**CITY OF ALBUQUERQUE
PLANNING DEPARTMENT
October 7, 2015
DRB Comments**

PROJECT # 1004980

APPLICATION # 15-70358

RE: Tracts C1 & C2, With Addition

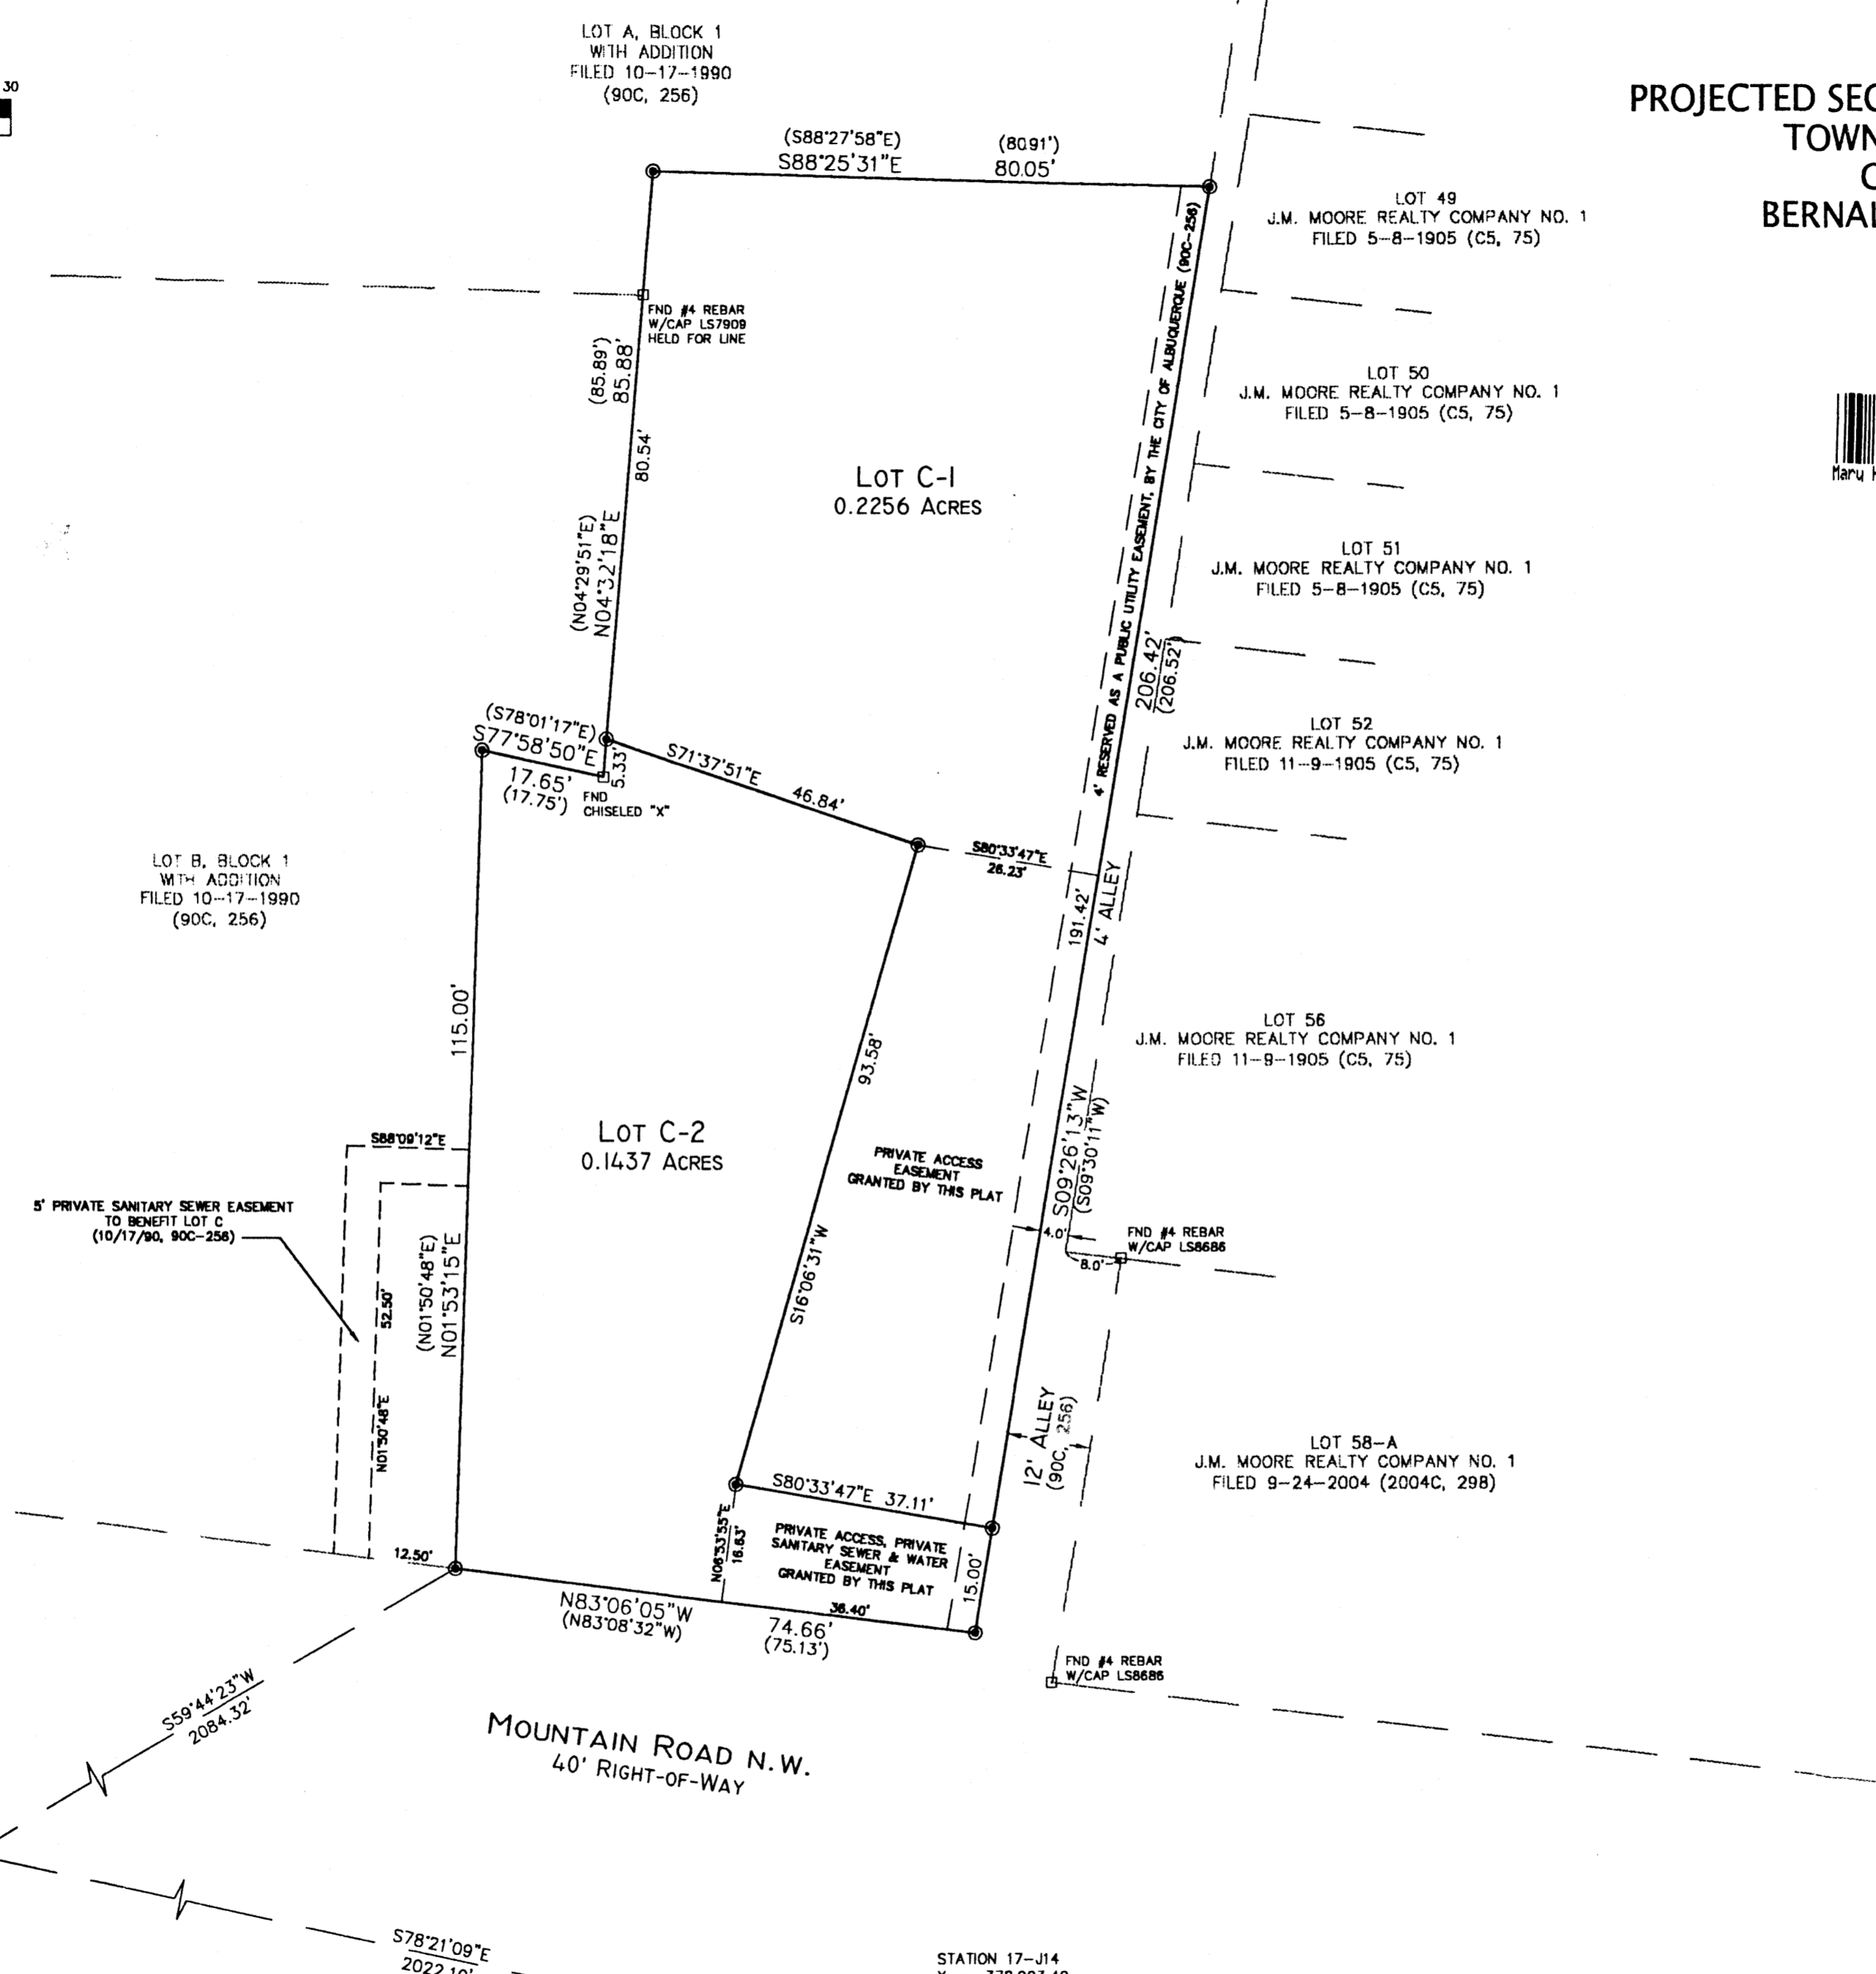
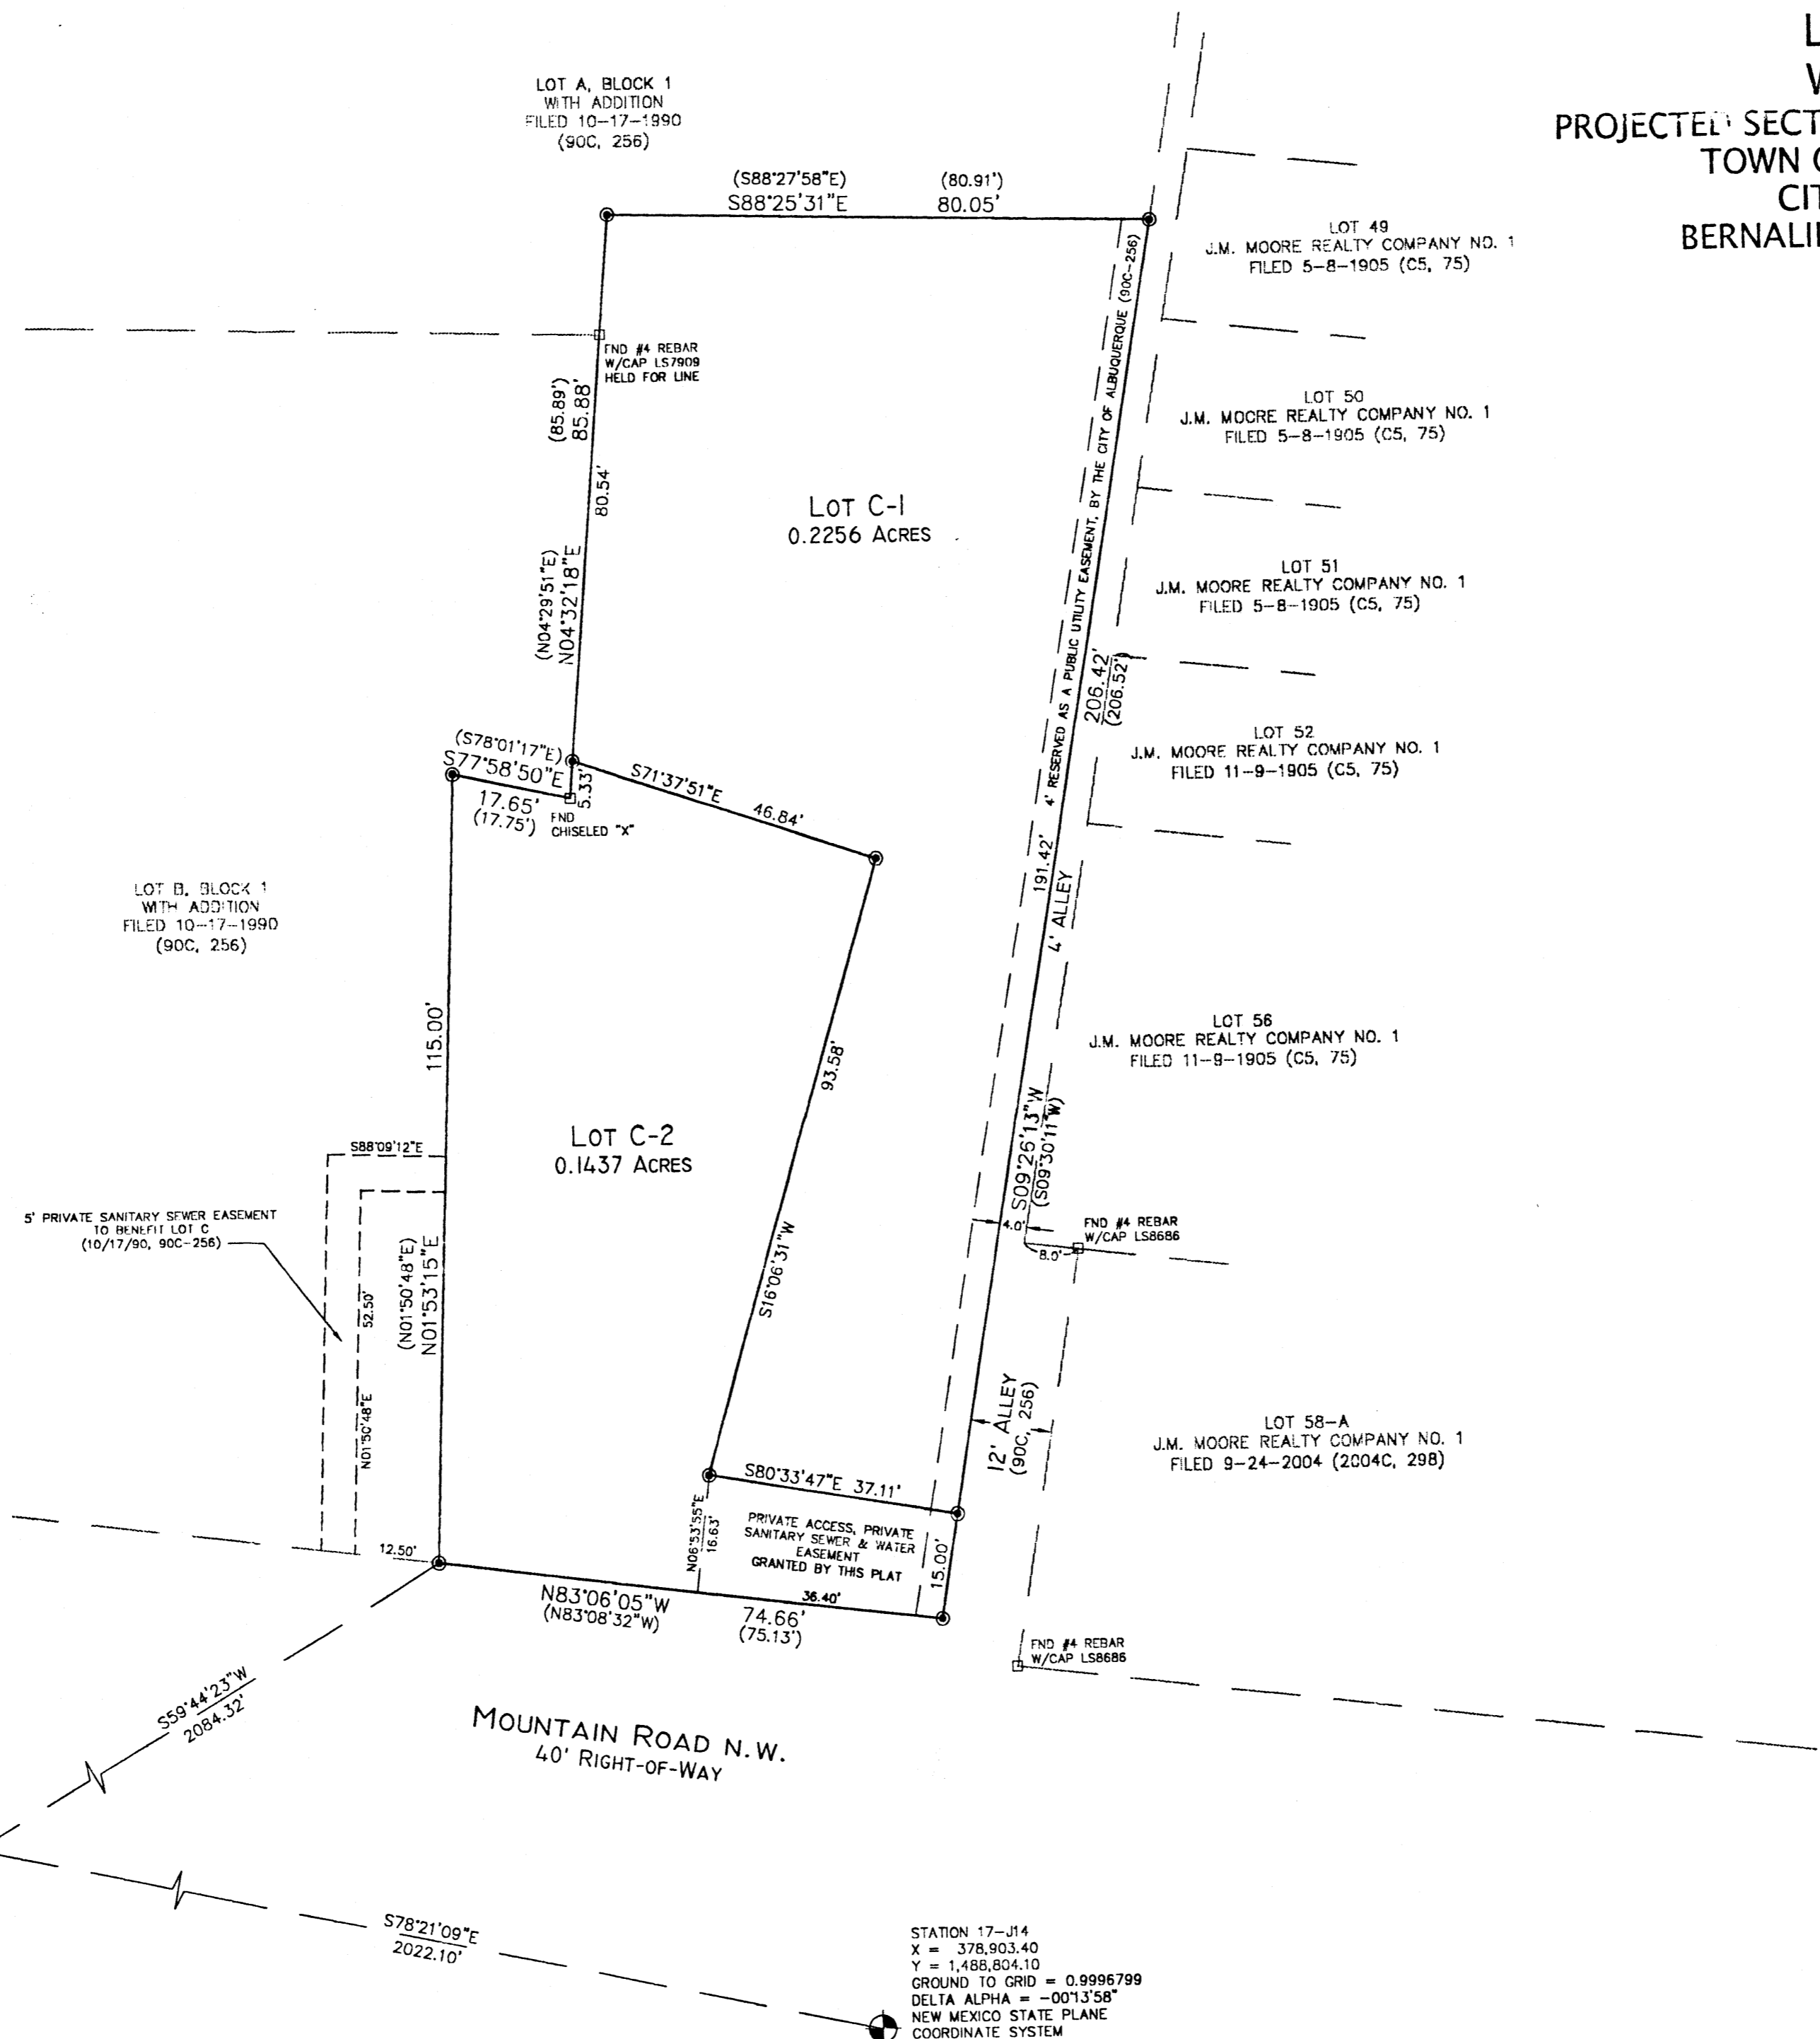
'Flag lots are not allowed (the flag 'pole' does not meet minimum lot width requirements).

A 'rear' lot can be created with a minimum 22 foot easement over the 'front' lot (which could be shared by both lots).
